1166 Bank Street | Formal Review | Zoning By-law Amendment & Site Plan Control Application | Architects DCA Inc., James B. Lennox & Associates Inc.

SITE PLAN: NEW WORK

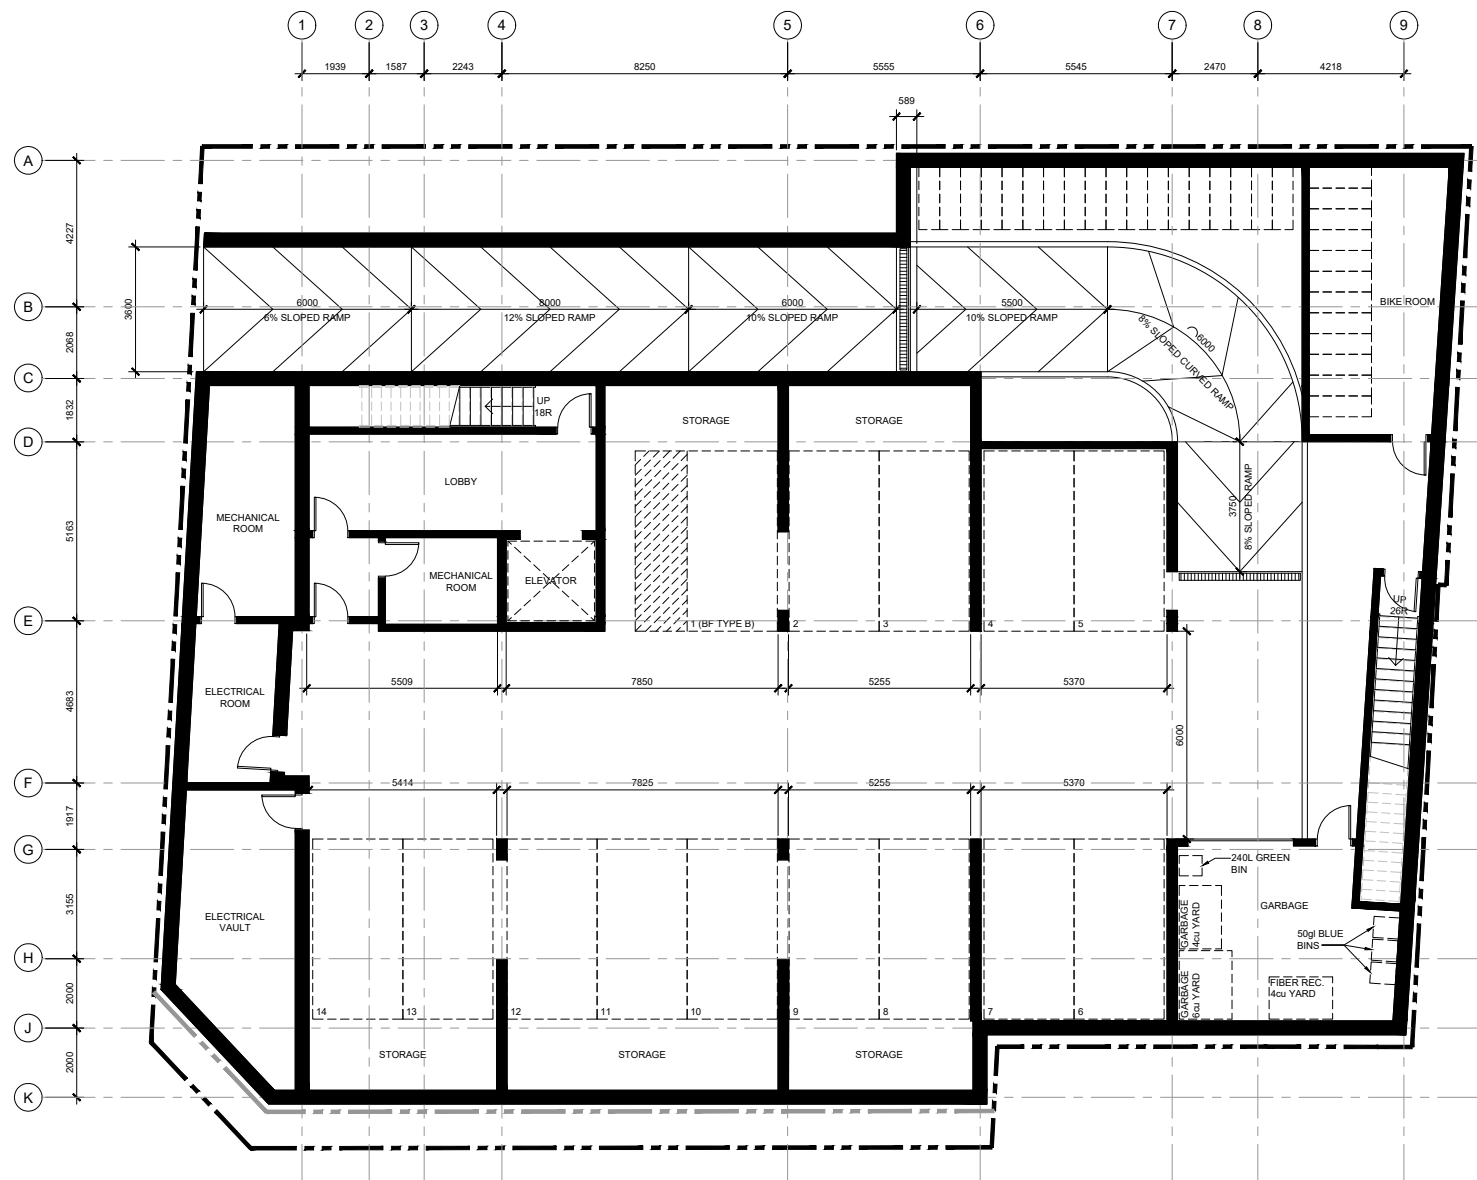
- Consider removing the softscaped green area along Bank Street at the north end and replacing it with a hardscaped condition, with pavers between the building and the sidewalk edge. This would allow the retail to be more connected with the street, keeping the public realm along Bank Street very clean and simple.

- The Panel has concerns with some unusual property lines on the site.
 - Consider coordinating with the City on the landscaped wedge at the north end of the property. Visibility to the commercial units is important.
- The Panel recommends reorganizing the bicycle storage/amenity/lobby area to maximize the size of the amenity space.
 - Consider moving the parking ramp closer to the property line and freeing up additional space for landscaping/amenity/bicycle access along the back of the building.
- The Panel recommends separating the waste storage for commercial tenants and residents into two separate rooms.
- The Panel recommends pursuing more of a hardscaped area with seating and street tree planting for the corner condition, rather than a softscape area.

**DRAWING TITLE**  
 FLOOR PLAN: GROUND

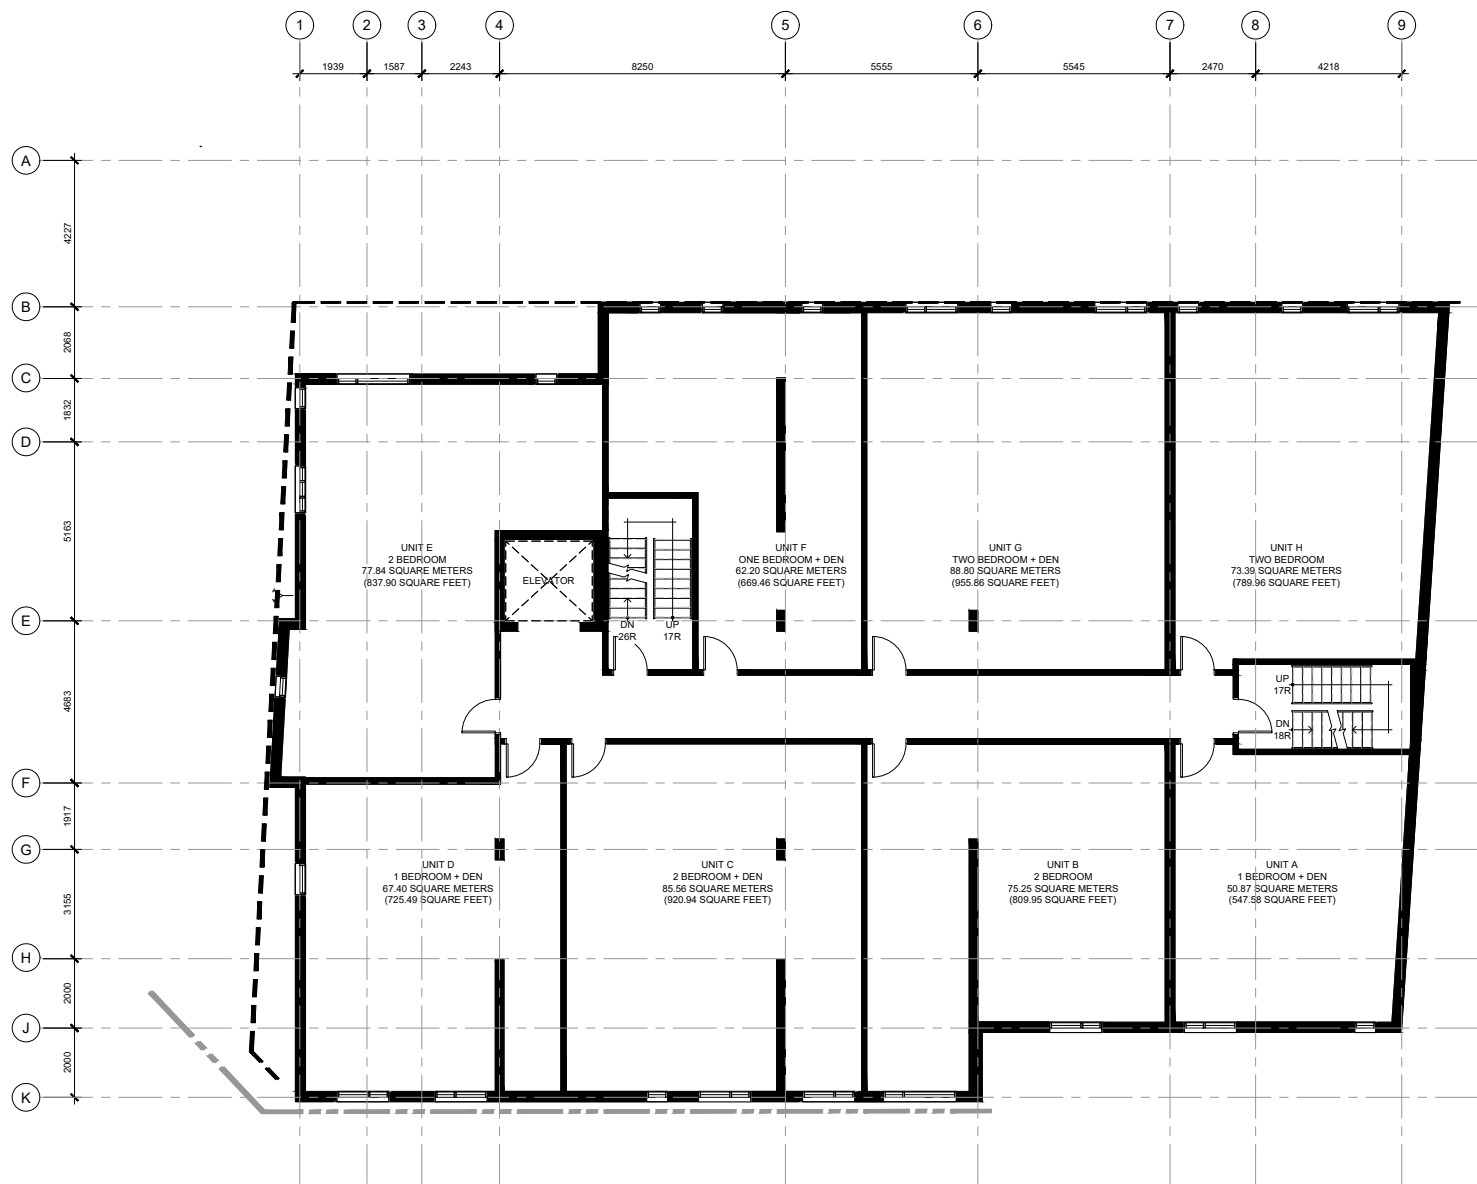
- The Panel recommends redesigning the stairwell at the north end of the building to enter/exit at the rear (northwest) corner of the building, ultimately giving the street-frontage back to the commercial use and providing more flexibility.

WEST ELEVATION

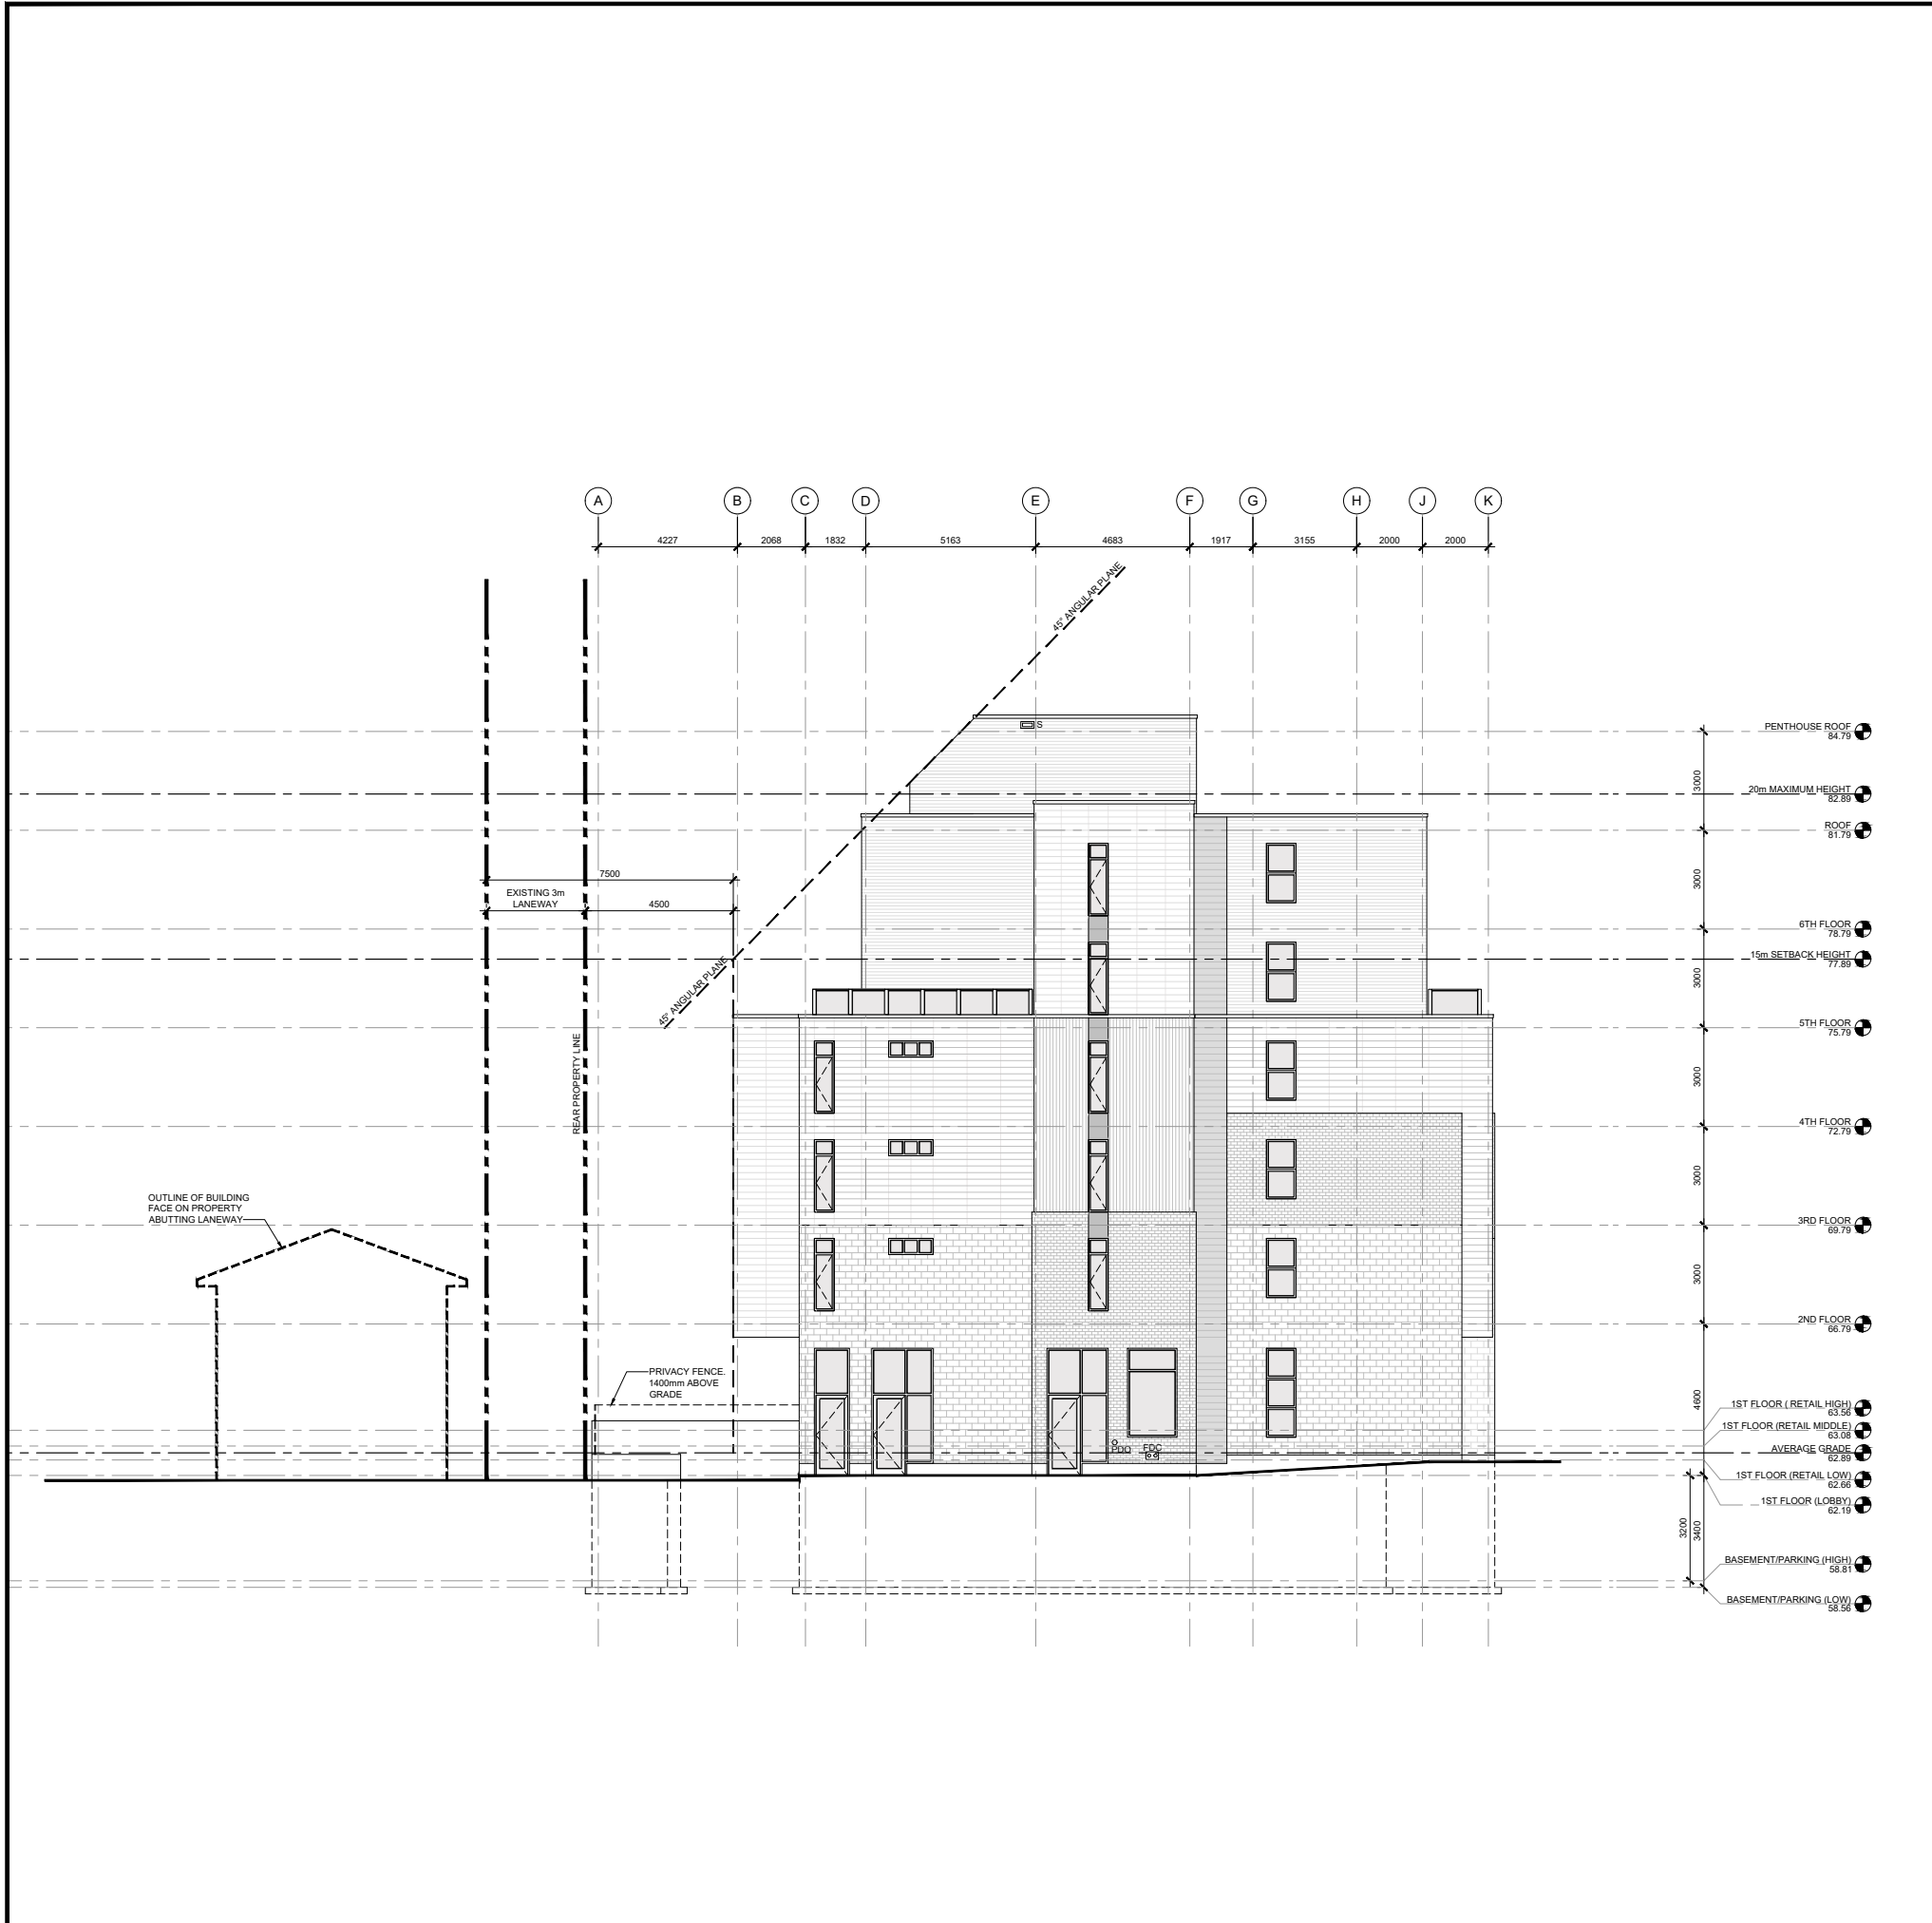
- The Panel recommends exploring options to reorganize the parking garage ramp and allow for more amenity space on the west side of the building.
- Consider tucking the parking ramp under building and within the building envelope. Otherwise, consider moving the parking ramp further west and allowing for a pathway/amenity area along the back of the building.
